RE: Site 8B Commercial Building, Murray Rose Avenue, Sydney Olympic Park, MP 10_0214

I refer to the above Major Project Application, which was referred to Sydney Olympic Park Authority (the Authority) for comment. The following comments are made on the proposed development, based on issues that the Authority requires further involvement from the applicant:

Section A-A

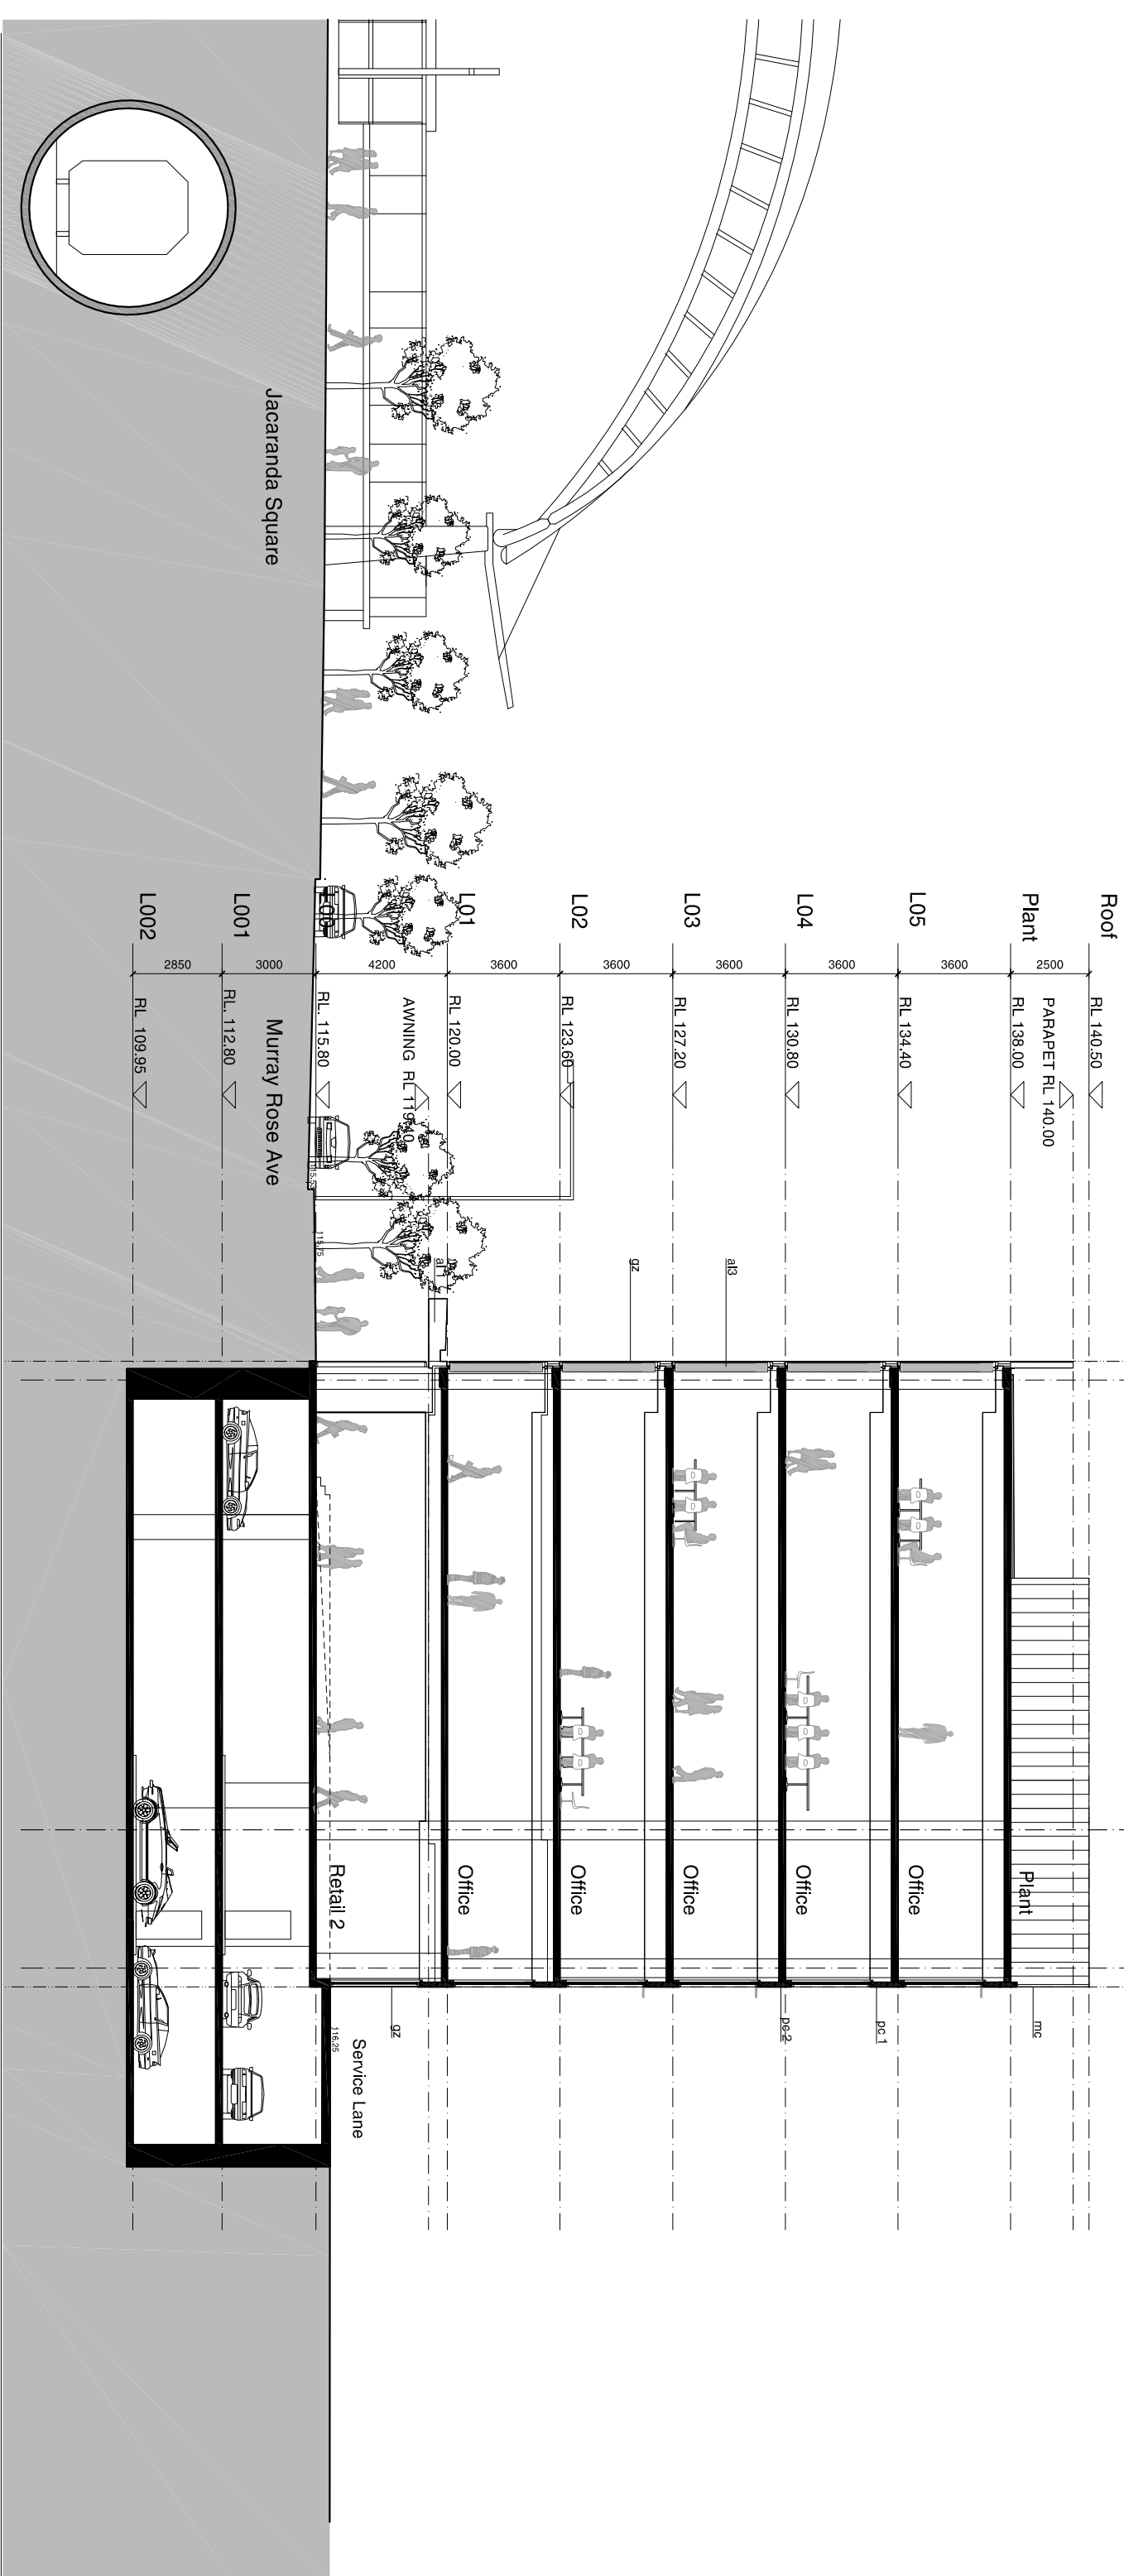
It appears that the floor to floor height on the ground floor does not comply with MP 2030. At minimum, the clearance should be 3.3m (higher clearance is desirable). Note: Drawing No. A06.002(C) indicates an RL of 129.4 (correct RL is 119.4) to the soffit of the awning.
